**From:** Geof Mansfield <gmansfield@ncc.nsw.gov.au>  
**Sent:** Tuesday, 20 July 2021 10:27 AM  
**To:** Katelyn Symington  
**Subject:** FW: Modification 1 Additional areas and layout (SSD-7698-Mod-1)

**From:** Geof Mansfield <gmansfield@ncc.nsw.gov.au>  
**Sent:** Tuesday, 20 July 2021 10:16 AM  
**To:** Katelyn Symington <Katelyn.Symington@planning.nsw.gov.au>  
**Subject:** FW: Modification 1 Additional areas and layout (SSD-7698-Mod-1)

Further to my email of 18 July 2021 and our telephone conversation of earlier today it is confirmed the applicant's response to Items 2 - Contamination and Item 3 - Environmental Impacts has been reviewed by our Environmental Health Coordinator and the following advice has been provided:

Figure A3.6 Predicted Incremental Annual Average Dust Deposition Levels (g/m²/month)

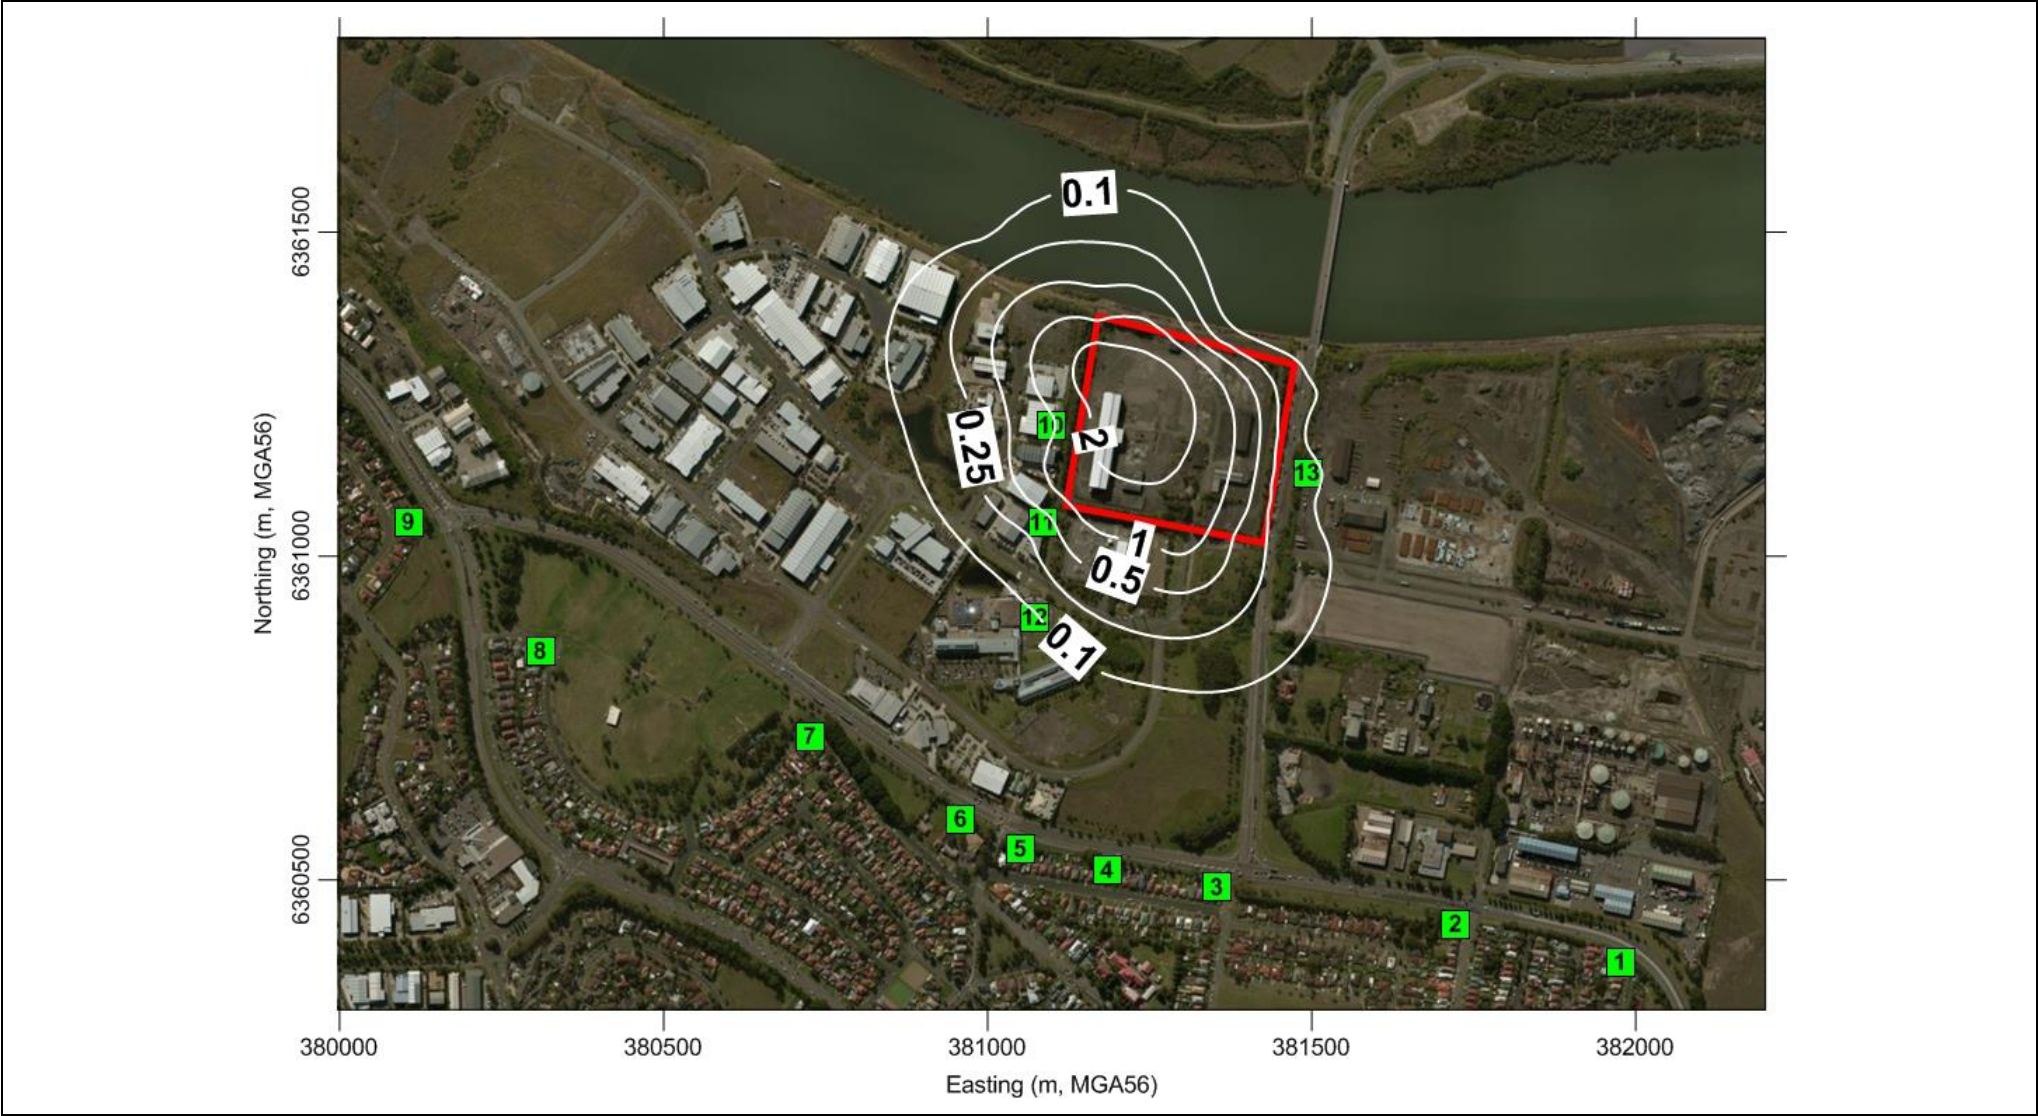
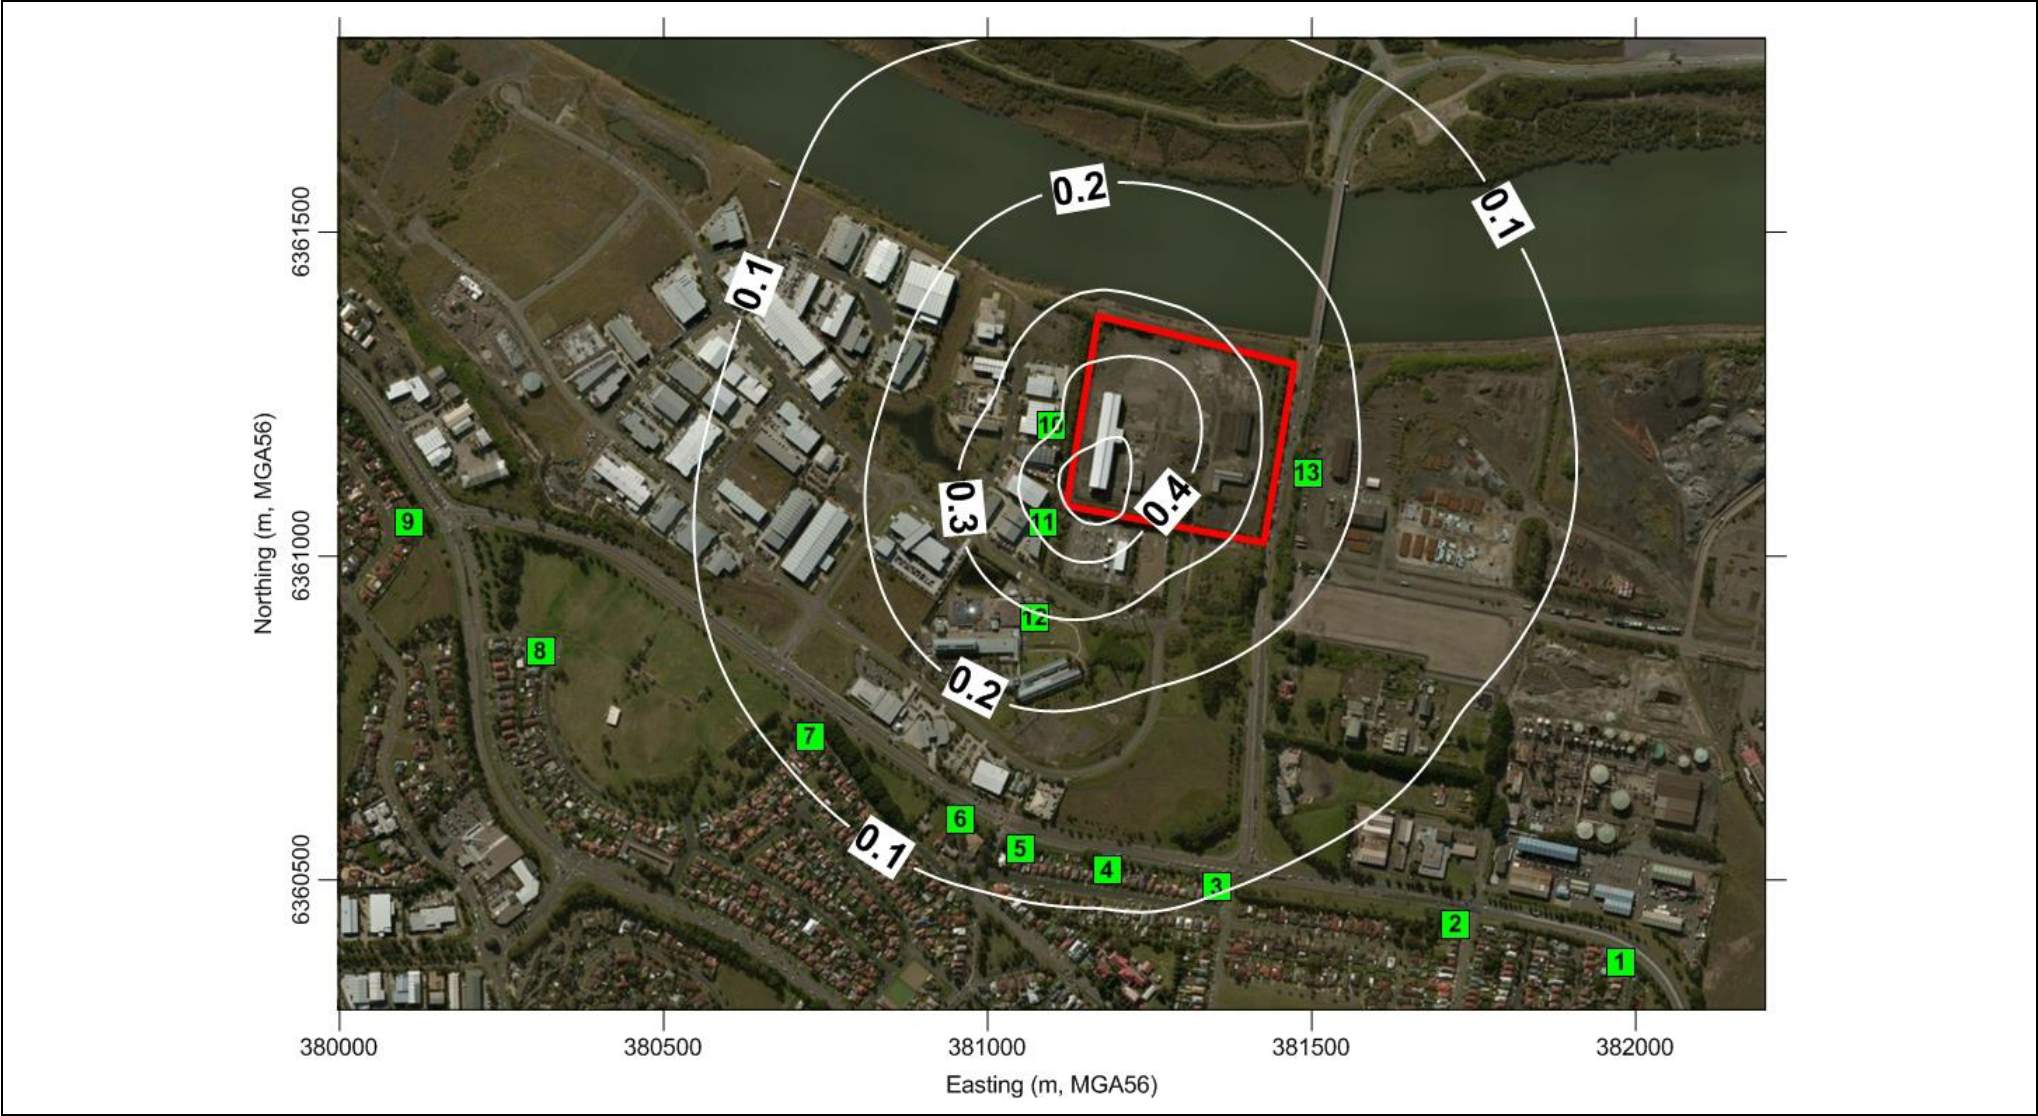
*They have considered our comments and note that there were errors in their previous documentation. They have reviewed the air quality impacts associated with the proposed increase in stockpiling area and provided revised information. This accuracy of the revised information and the significance of the predicted increase in air emissions can be reviewed and addressed by the appropriate regulatory authority (NSW EPA). '*

Figure 4. Layout plan for proposed hand unload shed and apron area

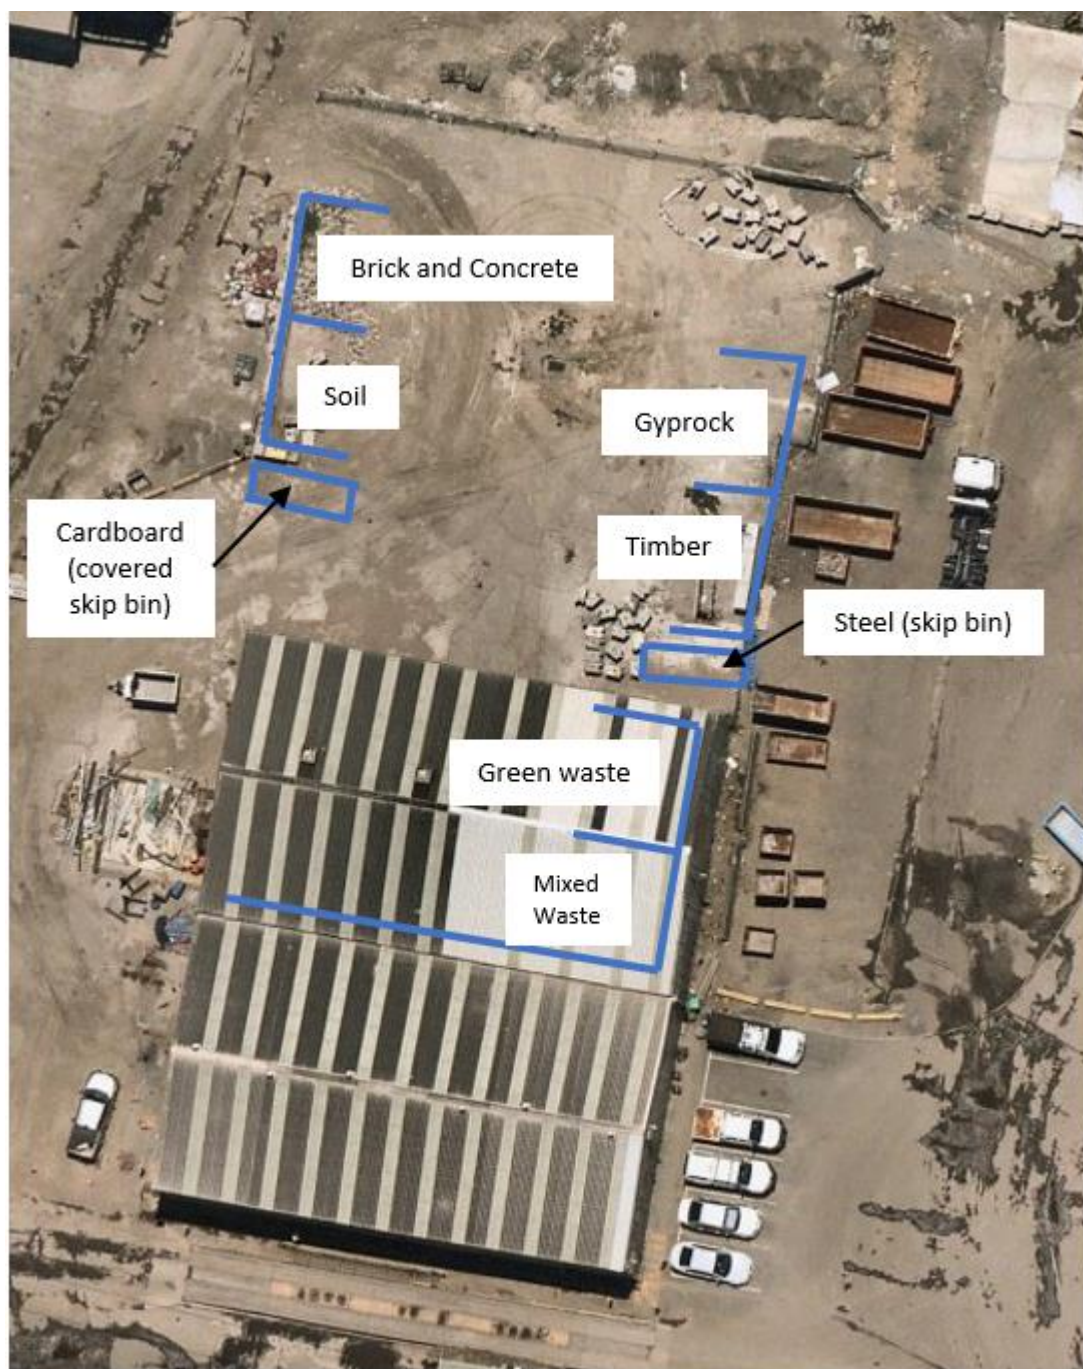
In regard to the second dot point of item 1 -Section 4.55 (1A) application concern is raised at the adequacy of the supplementary information provided in demonstrating how the proposed maintenance activities are ancillary to the approved State significant development. No specific details have been provided of the following:

- Identify the type and number of vehicles to be serviced.
- The role and use of the 'on-site vehicles and associated equipment' in the approved waste management activities on site.

- The number of proposed staff associated with the maintenance shed. Given the modification report states that there will be no change to the number of staff associated with the proposed modification, where are these staff currently employed on site?
- What are the hours of operation of the maintenance shed?
- What waste will be generated by the proposed maintenance activities?
- Will the maintenance activities create any environmental impacts and how will they be addressed?
- A floor plan of the proposed use of the shed .

It is recommended that clarification be sought from the applicant regarding the above matters.
